Article 21 of the Town and Country Planning (General Development Procedure) Order 1995
Application for approval of details reserved by conditions 3, 4 and 7 of LY/1/13 - Landscaping,
drainage & bat owl habitat
Barn at Calceto Lyminster,,

Arun District Council have decided to **REFUSE details reserved by condition for the following reasons:**

REVISION PROJECT Conversion of farm building at Calceto Farm, Lyminster		
SUBJECT Site Plan and Location Plan		
SCALE	DATE May 2013	DRAWING No 2012 / 23 / 13
DRAWN	CHECKED	
		Rev B

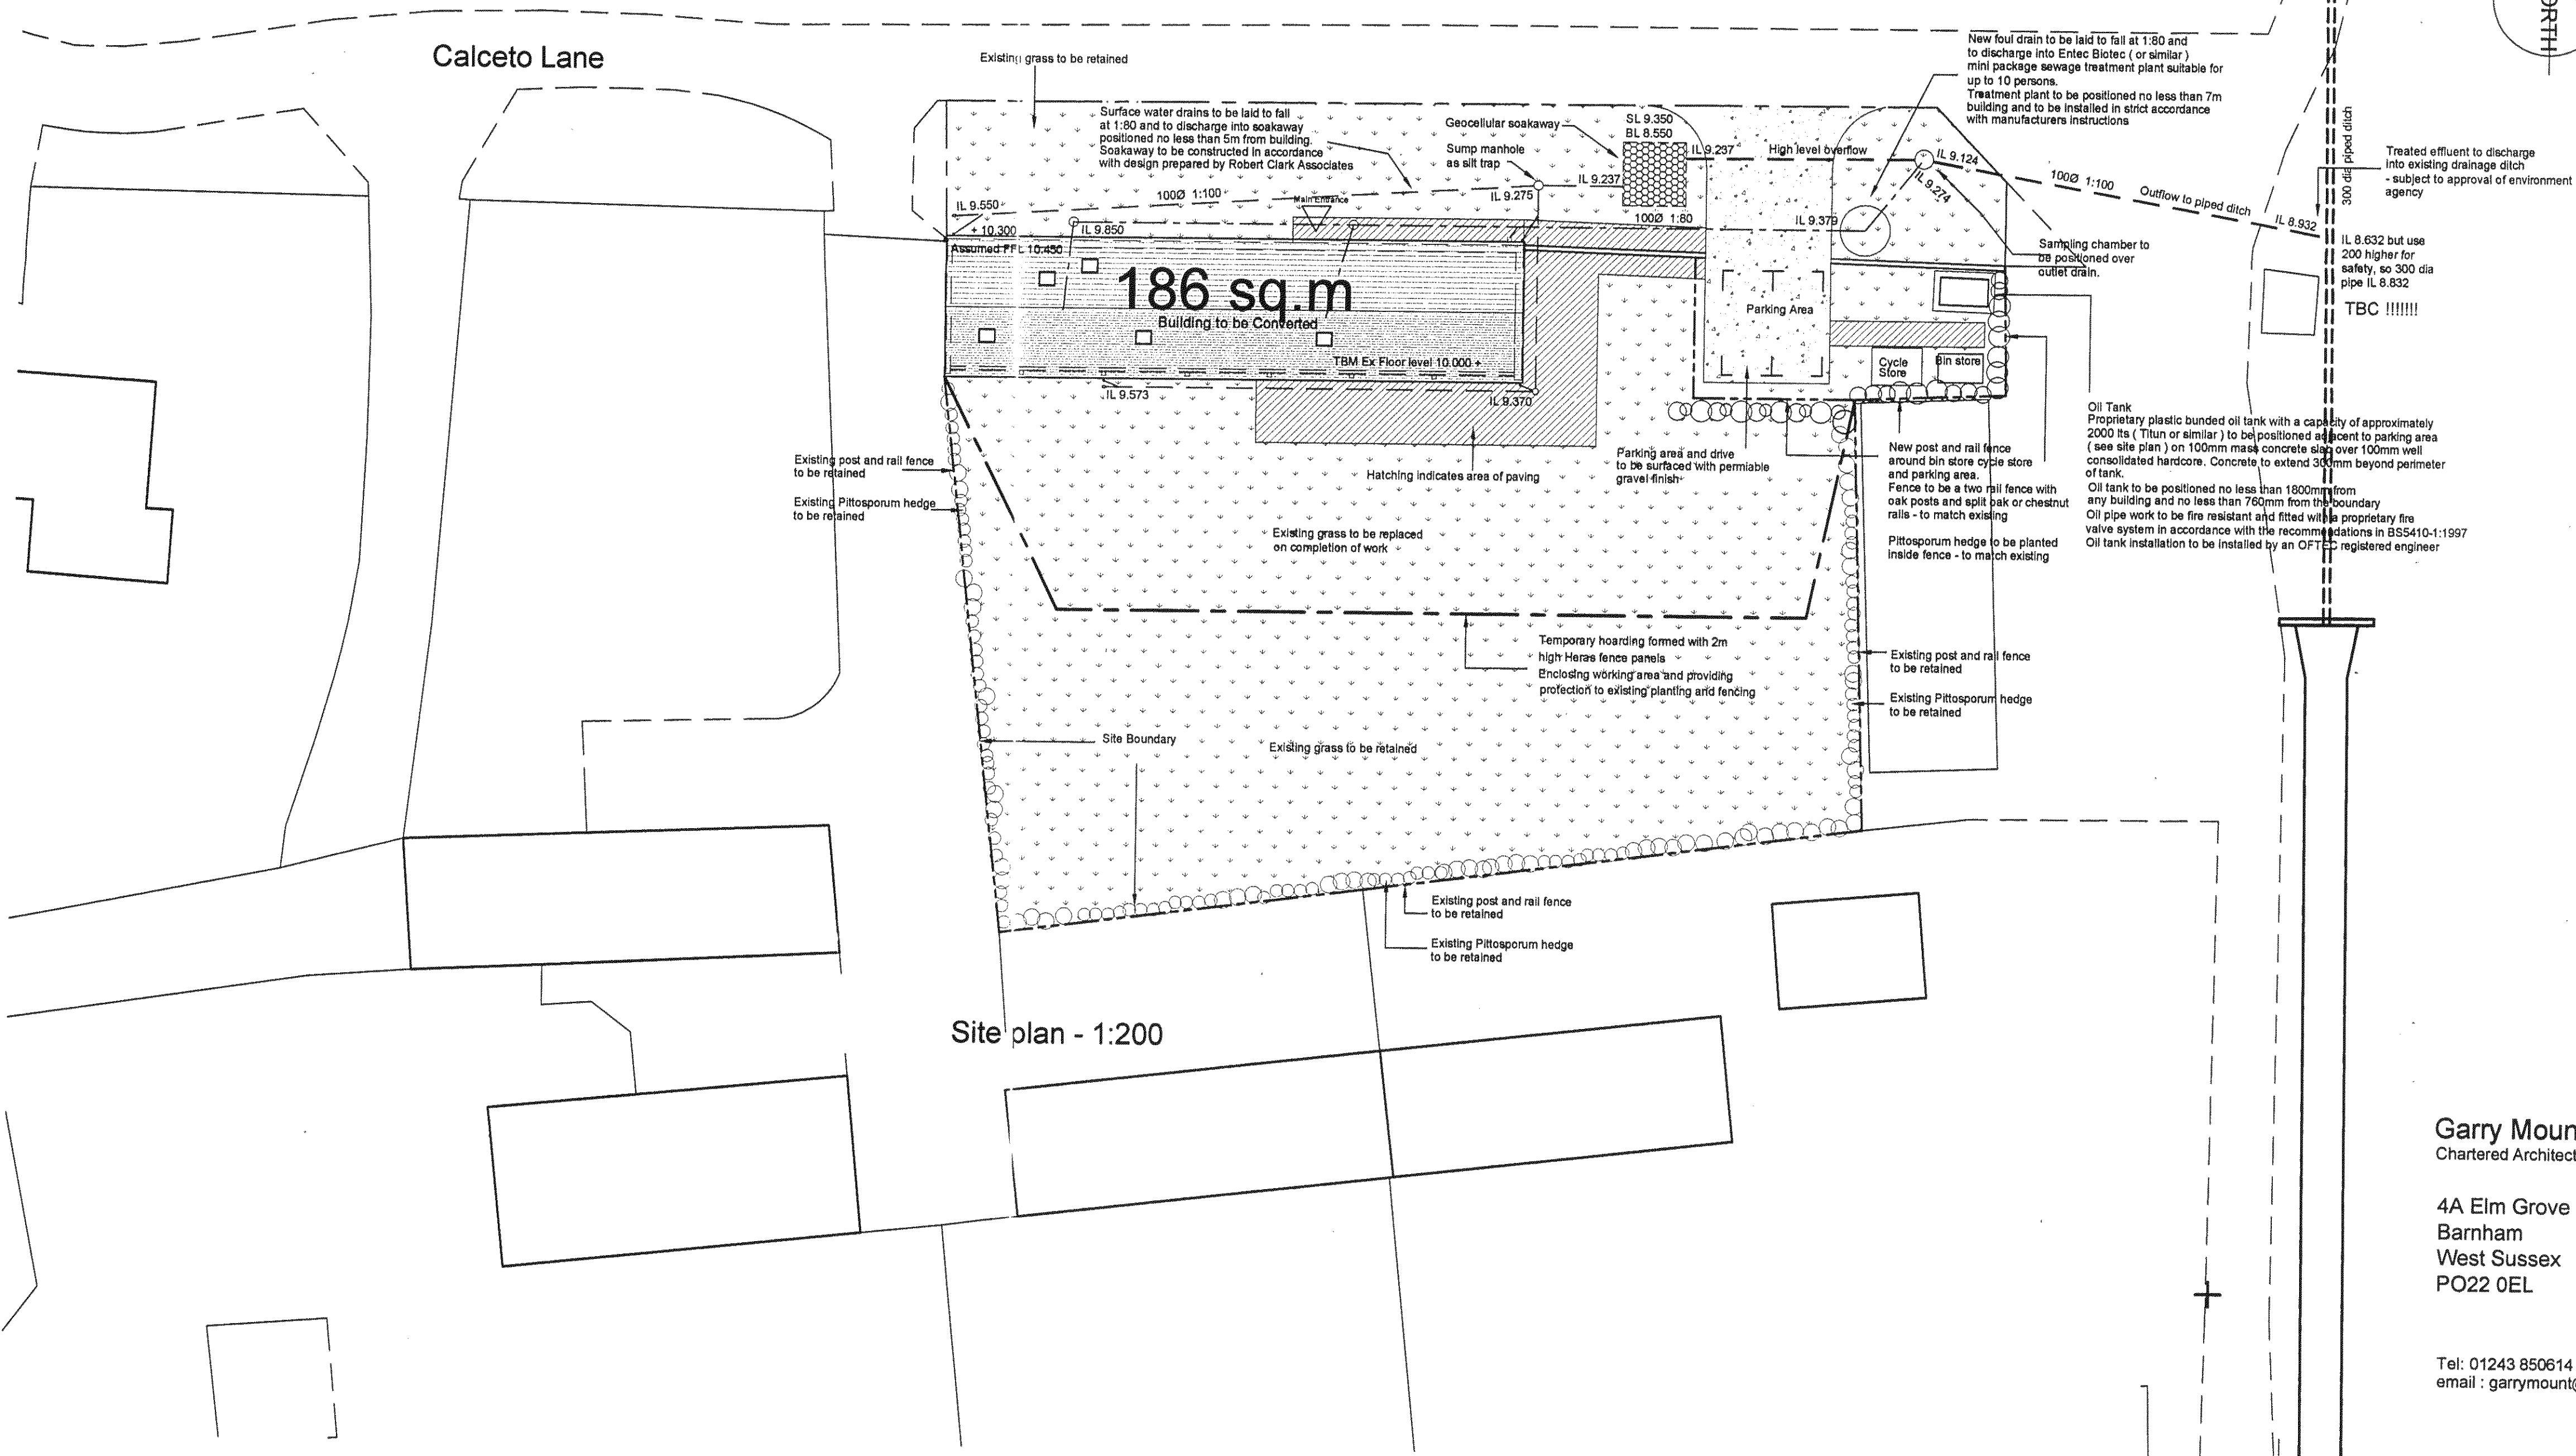
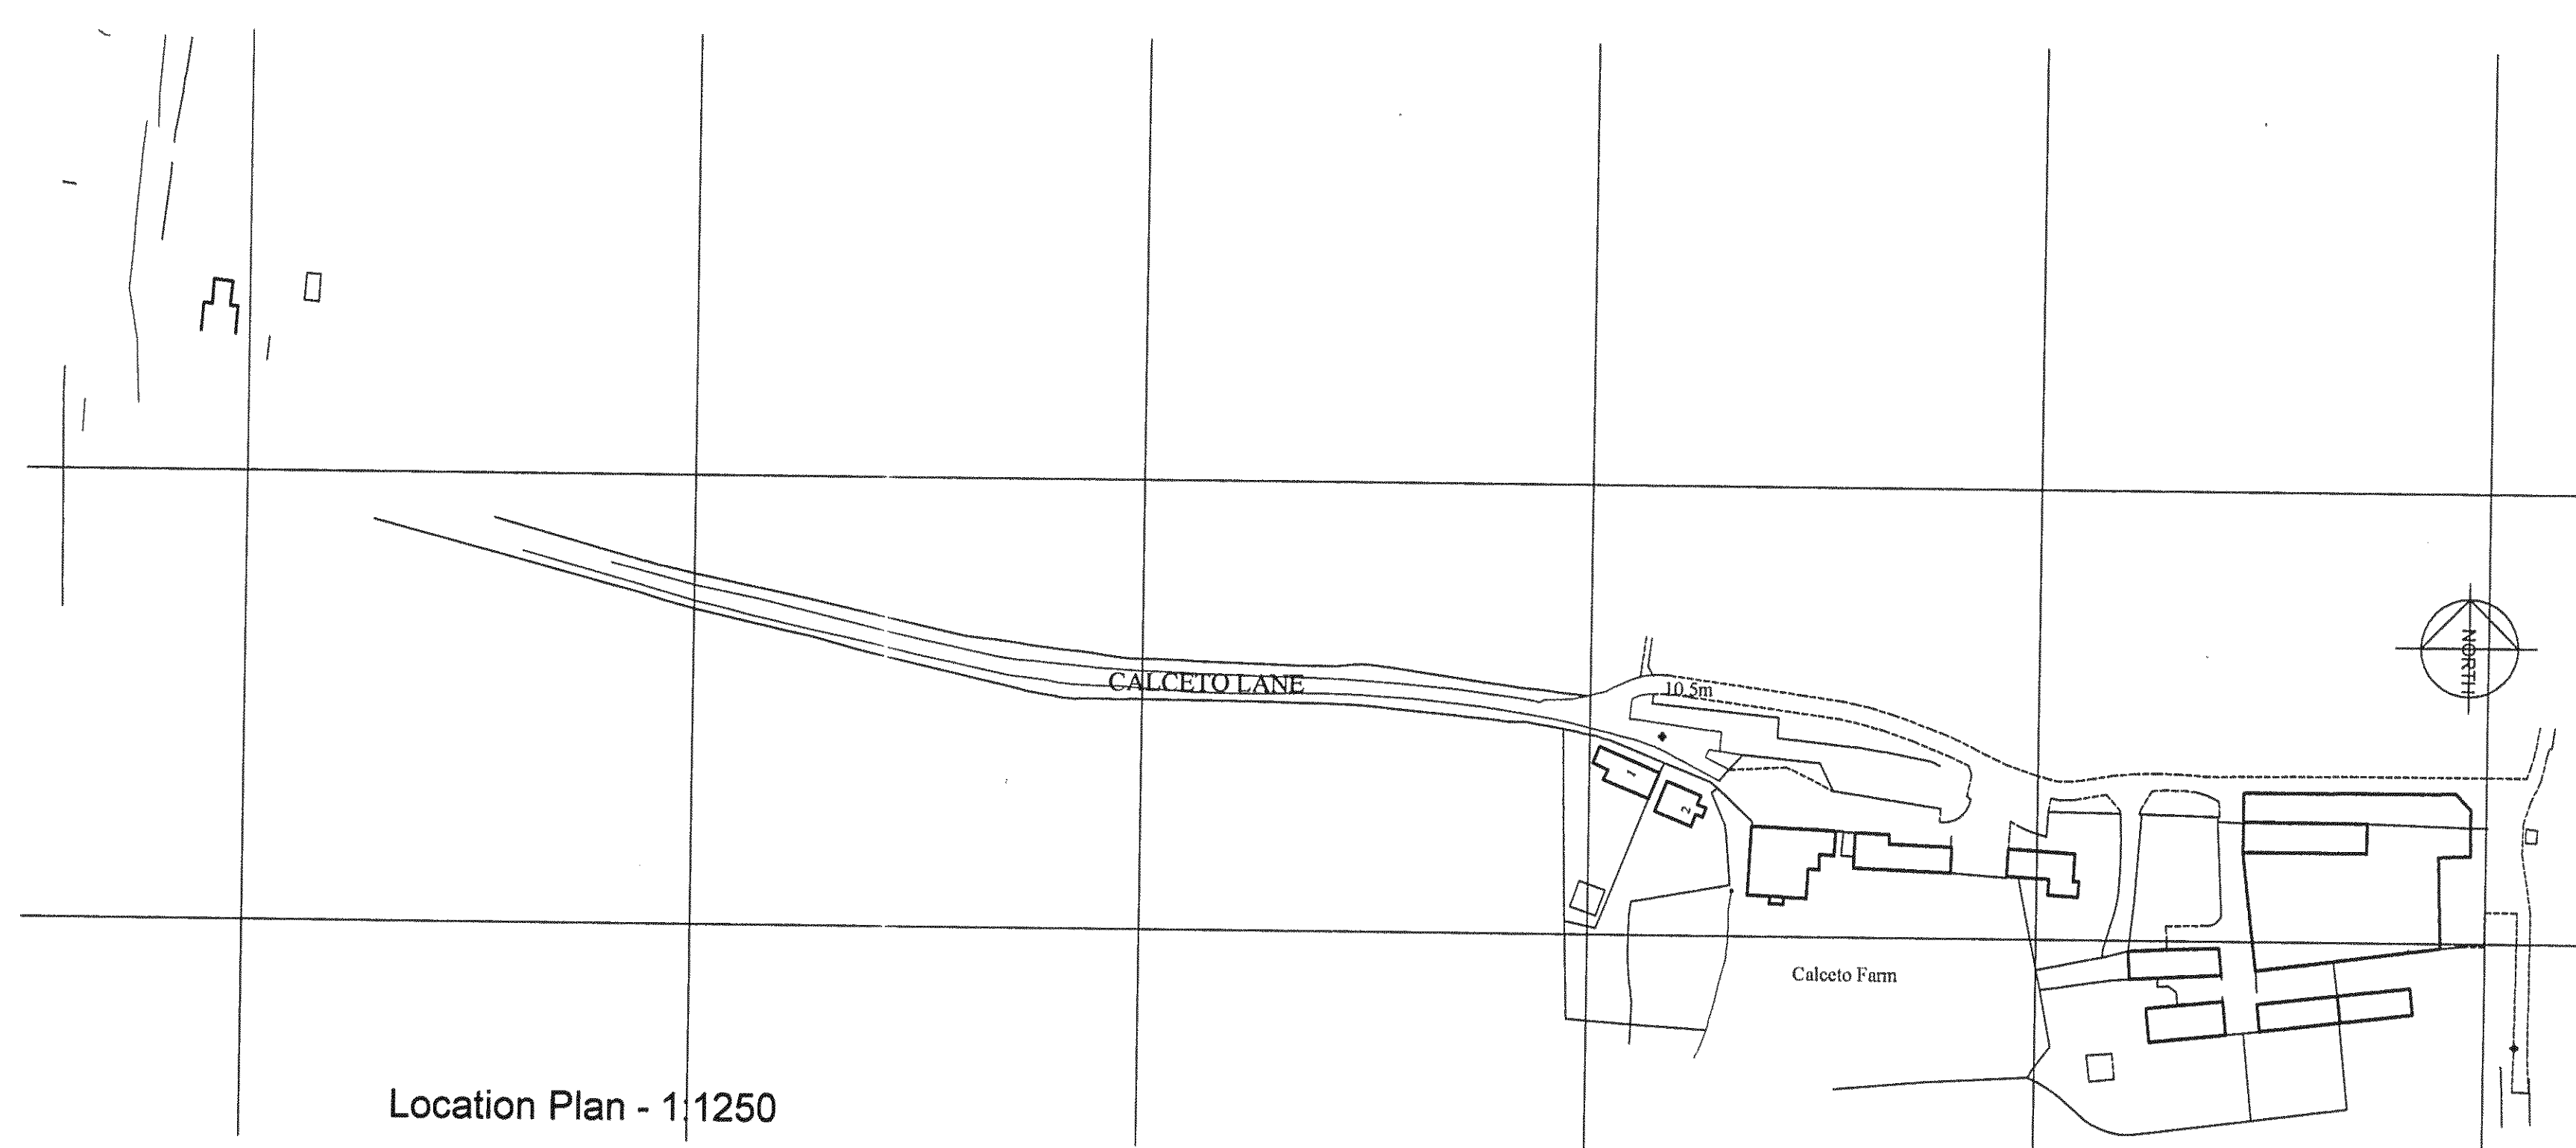
This condition cannot be discharged. There are no details of plant and pot sizes and number of proposed plants included in the application. In addition there is too much Pittosporum hedging included. More native hedgerow species should be utilised, particularly in the area surrounding the bin and cycle store. The landscaping details shown on drawing no.2012/23/13 revB also indicate provision of an oil tank which would need permission in its own right.
